Re: Request for Council's Advice on SEARS

Liverpool City Council was invited to provide comments on the Planning Secretary's Environmental Assessment Requirements (SEARS) for the proposed development of an automated distribution facility at Lots 4-5, 6-7 and 8 Buchan Avenue, Edmondson Park.

Attachment A – Detailed comments and required information

PROJECT TITLE SITE 03,04&05 BUCHAN AVE, EDMONDSON PARK 2174			DRAWING TITLE SHADOW DIAGRAMS - SHEET 02	
CLIENT URBAN PROPERTY GROUP www.urbanpropertygroup.com.au			PROJECT NUMBER 20794	STAGE DA
APPROVED MB	CHECKED DC	DRAWN	DRAWING NUMBER DA-S4-4101	REVISION B

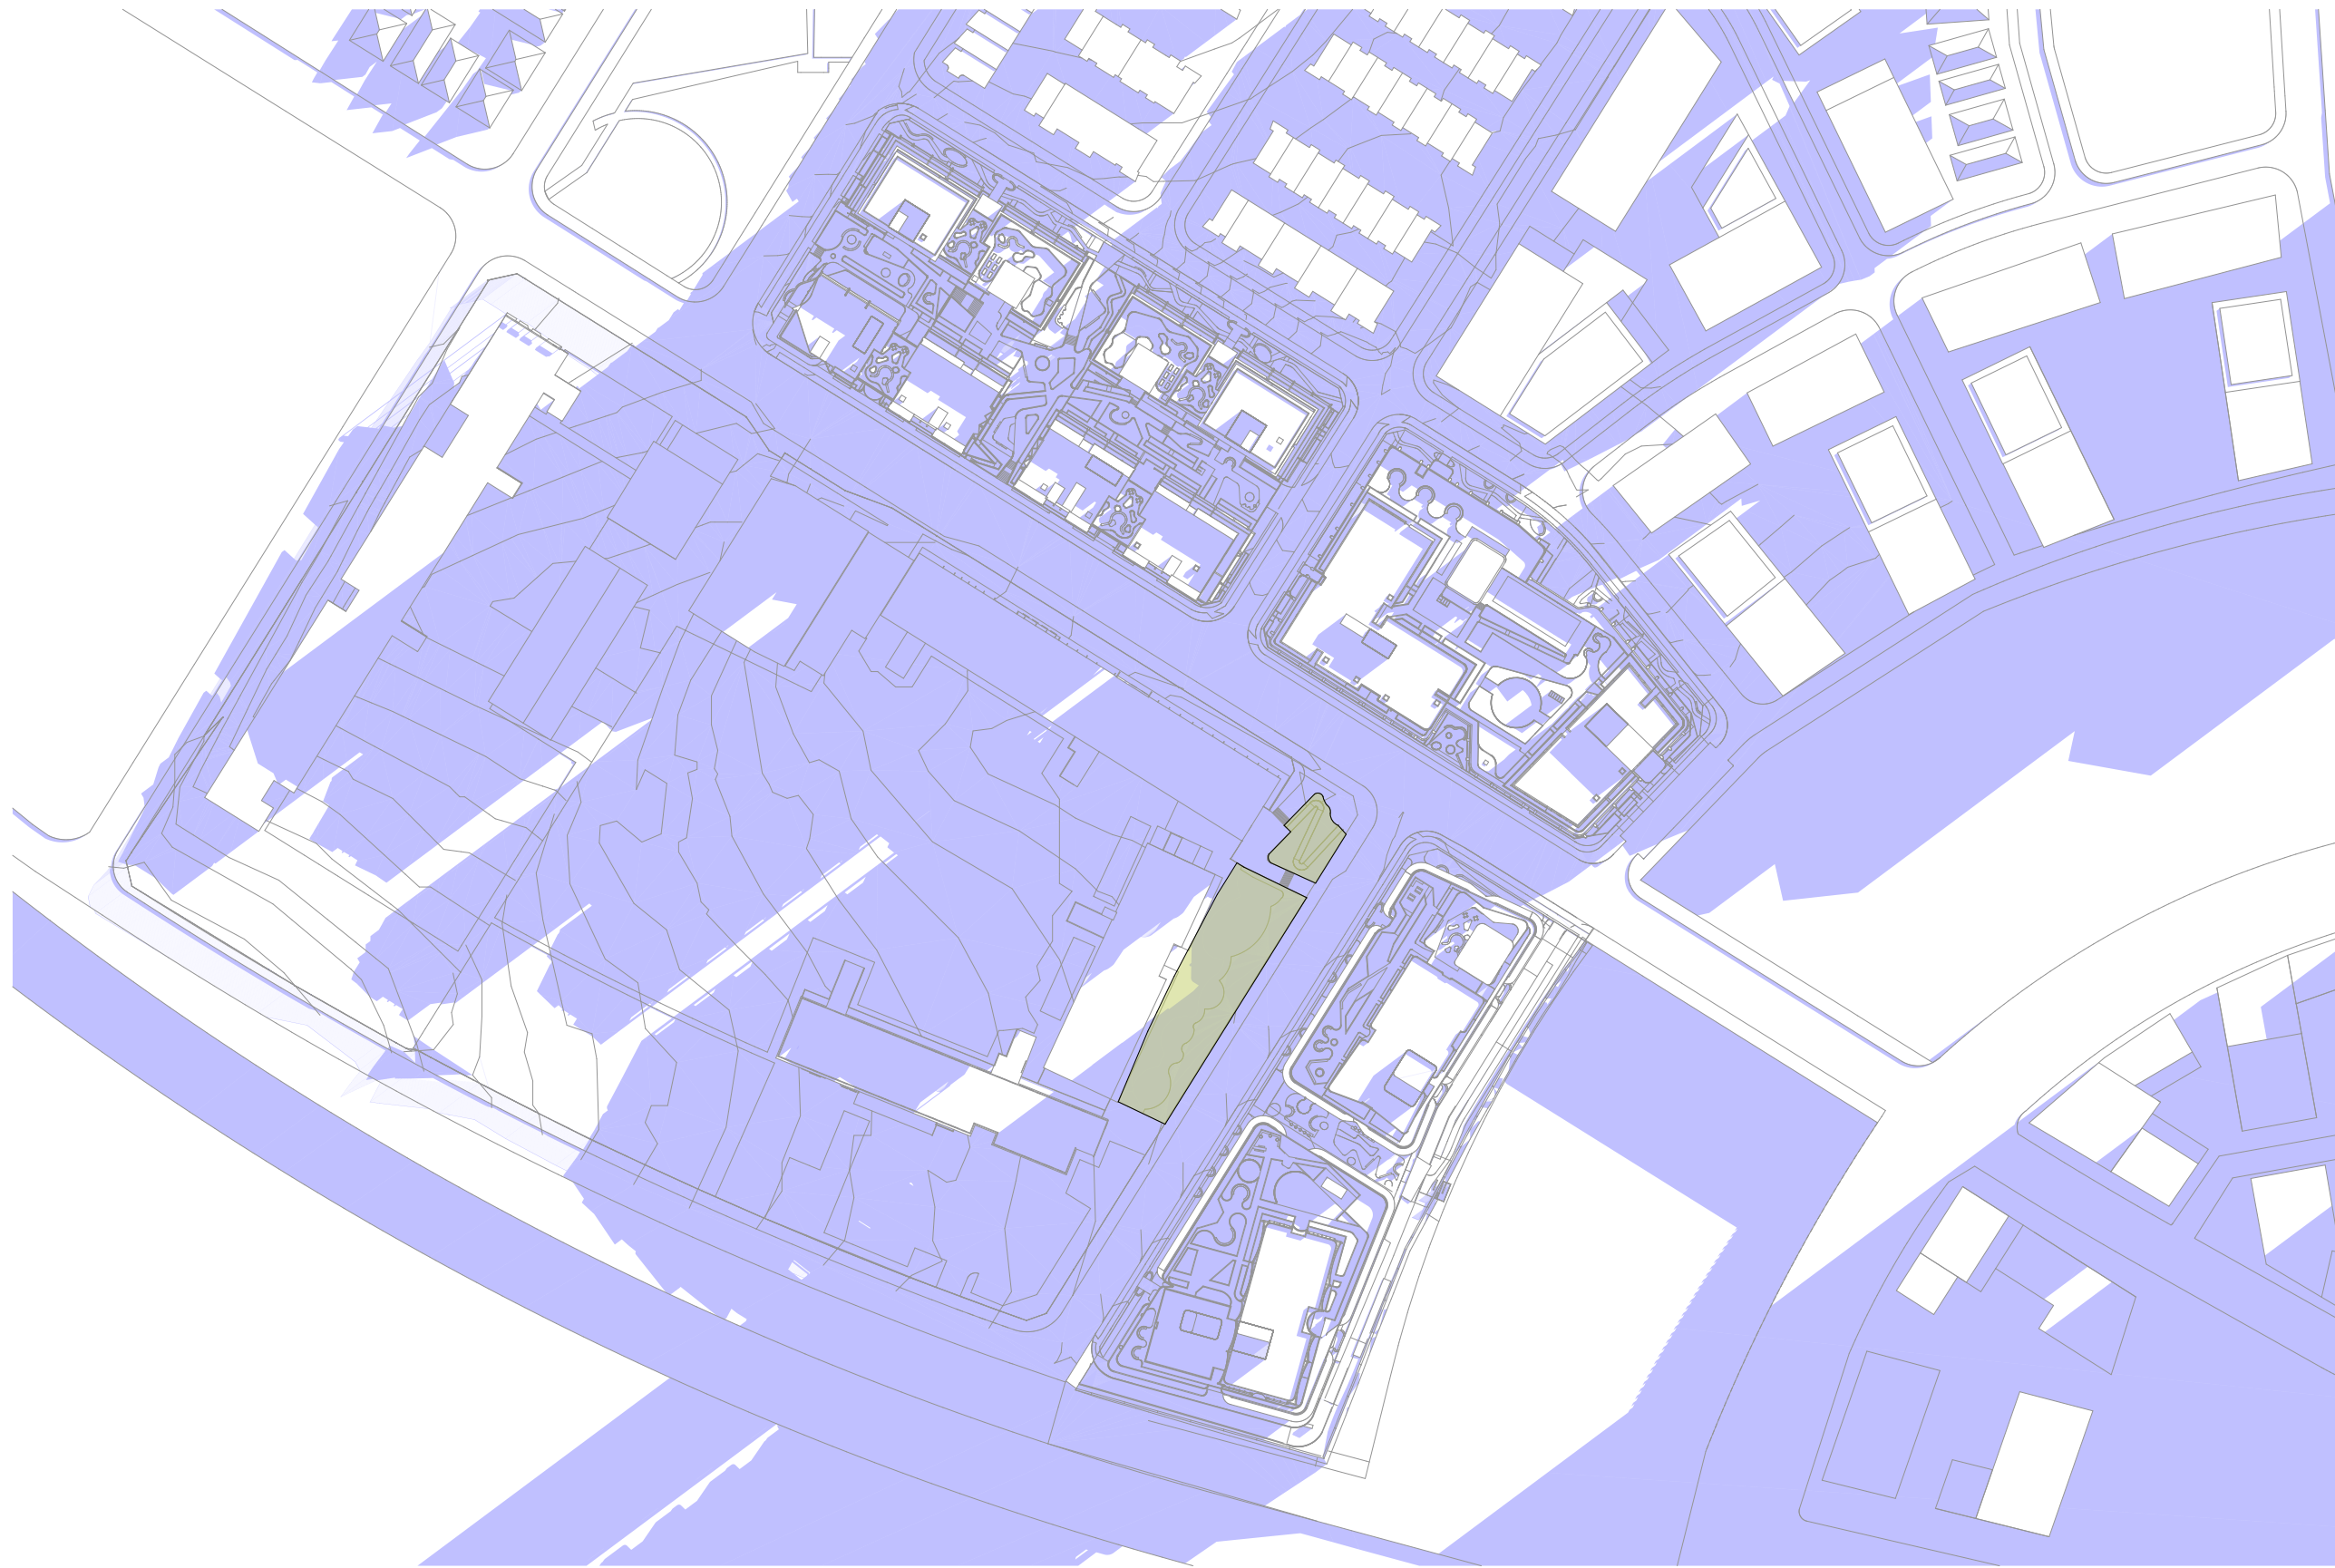
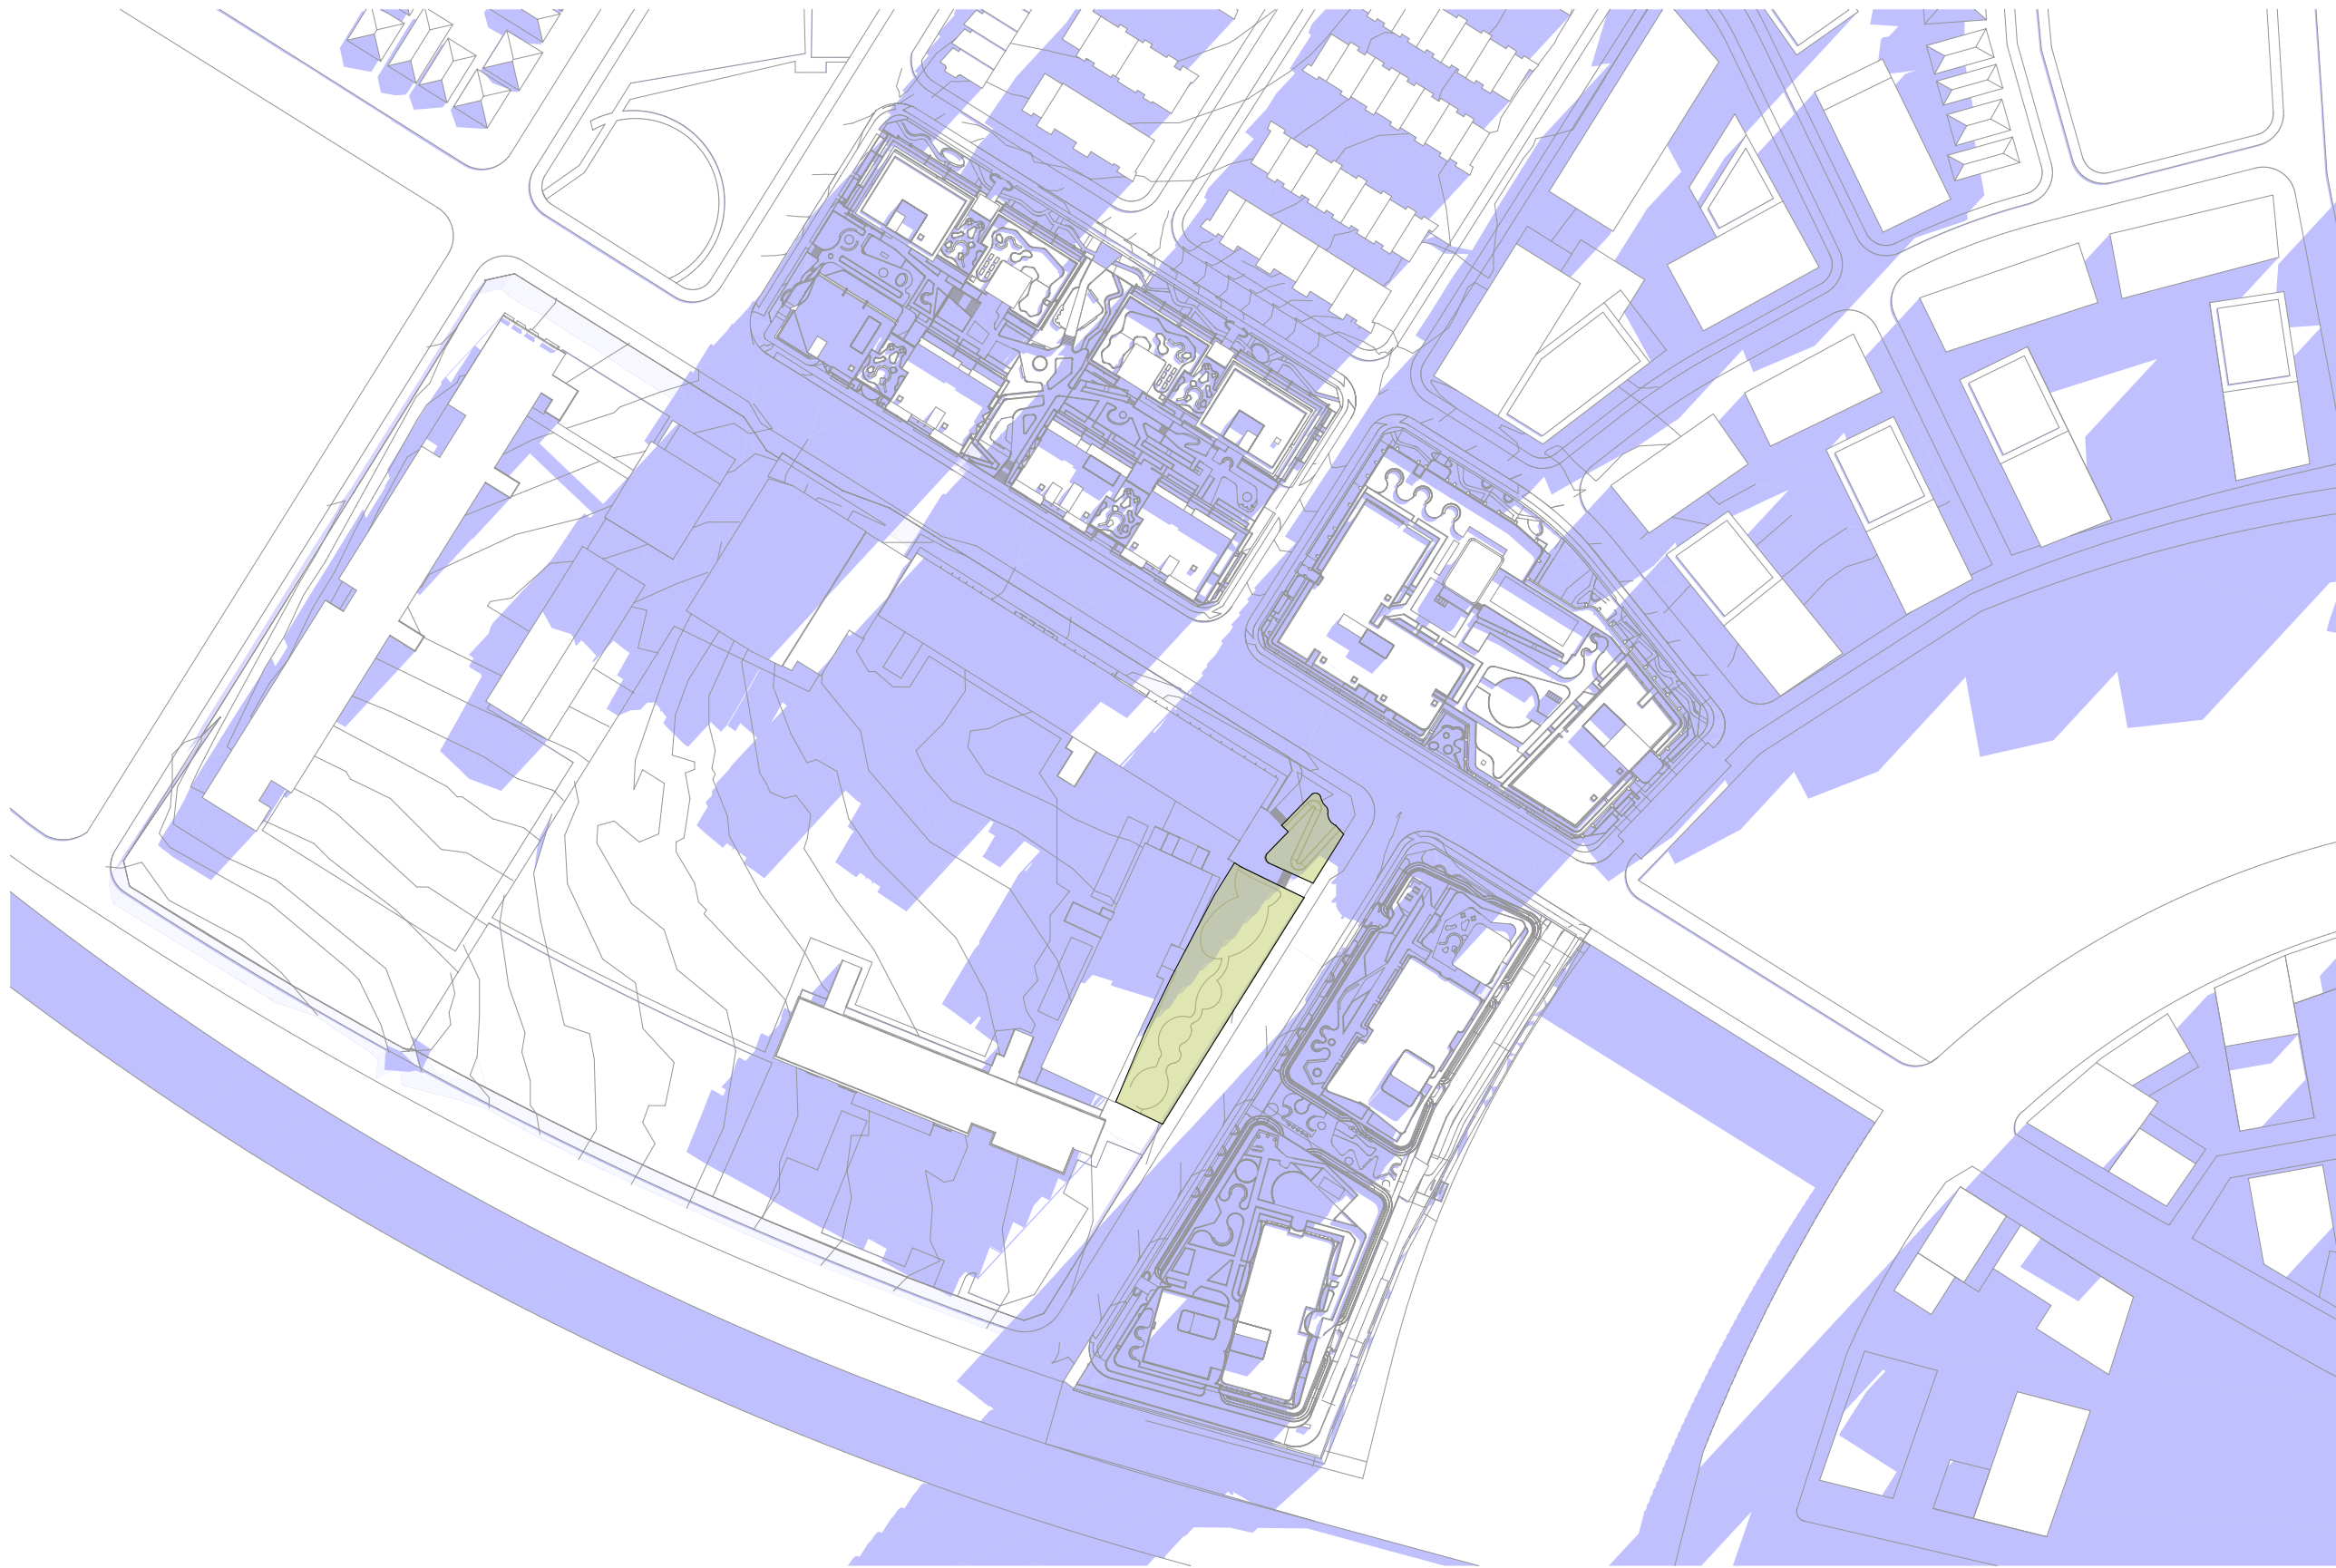
Strategic Planning are concerned about the bulk and scale facilitated by this concurrent rezoning and SSD. Overshadowing, and Overlooking analysis is required.

- Economic Impact Assessment including demand analysis for additional B4 Zoning in the area, and any additional retail land use (supermarket, gyms etc).
- Urban Design Report which includes analysis of bulk and scale, overshadowing of existing low scale residential dwelling, surrounding open space and schools.
- Infrastructure Demand Analysis
- Open Space Needs Analysis (including the additional needs as a result of additional density)
- Community Facilities (including the additional needs as a result of additional density)
- Social Impact Assessment
- Traffic Impact Assessment
-
